Your Ref: OWPC15549
Our Ref: A/121/17/HH 21-06-2017
Please ask for:
Mrs A Gardner

14th September 2017

Single storey extensions to existing garage and pool
Harcourt West Drive Angmering

<table><tr><td>PROJECT HARDCOURT West Drive, Angmering Littlehampton. BN16 4JE</td><td rowspan="4"> 29 Breach Avenue, Southbourne, Emsworth, Hampshire. PO10 8NB T: 01243 697164 M: 07879471666 www.pdkconsulting.co.uk</td><td rowspan="4"> PDK Architecture and Surveying</td></tr><tr><td colspan="2">DRAWING PROPOSED SITE PLAN</td></tr></table>

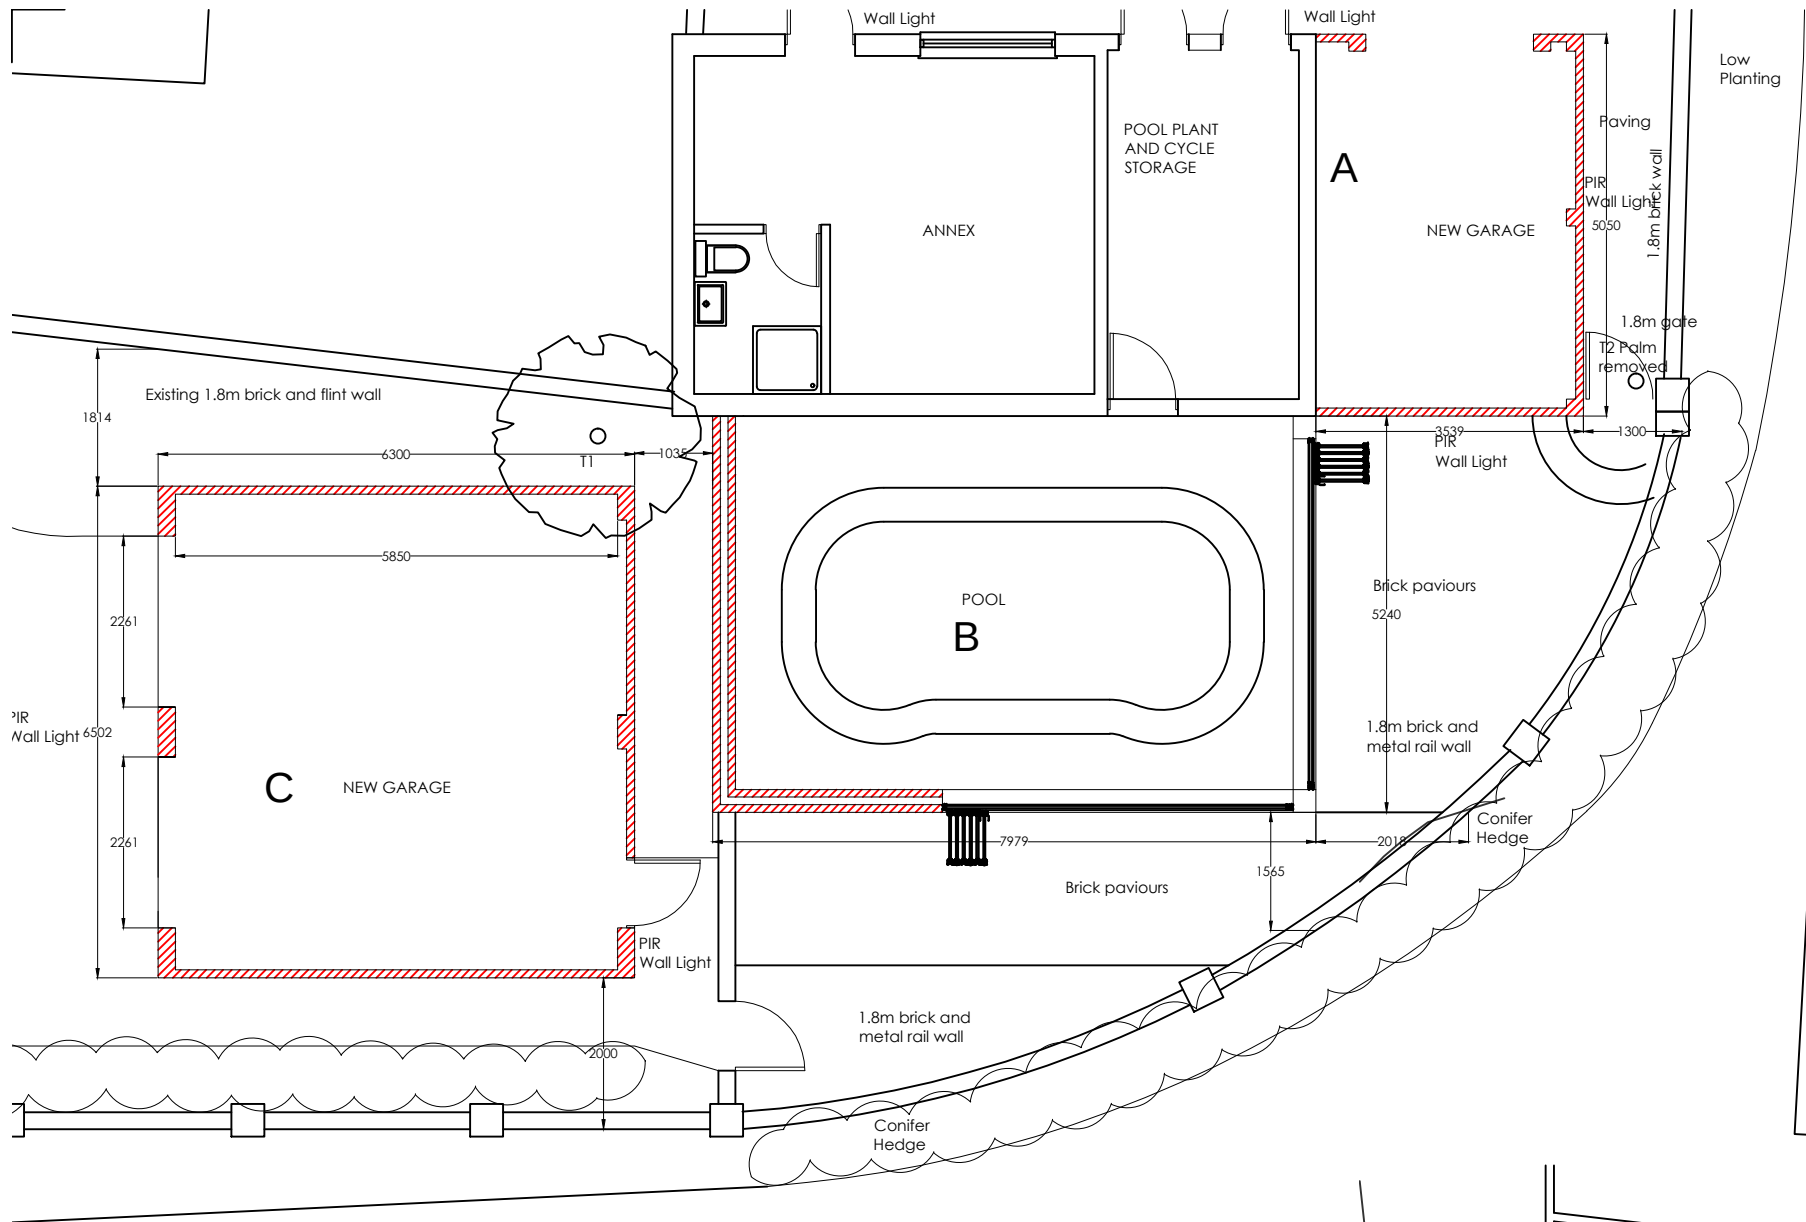
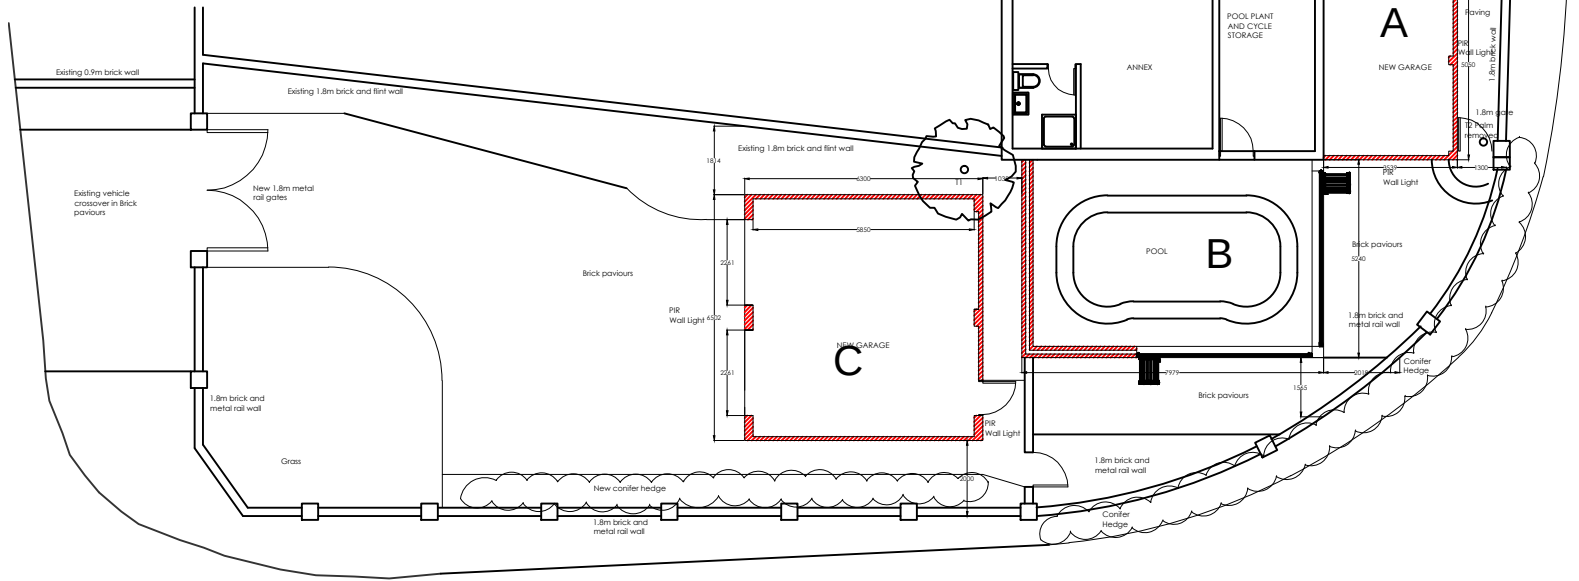
No objection to the building of a single garage extension with access as proposed. However, erection of the flat roof pool enclosure appears to be in front of the existing building line for the plot. Approval of this element of the proposal for erection of a building immediately abutting West Drive, would set a precedent for building on adjacent grassed areas abutting the road, plans for which the applicant previously included in the application against the overwhelming objections of local residents, already on file.
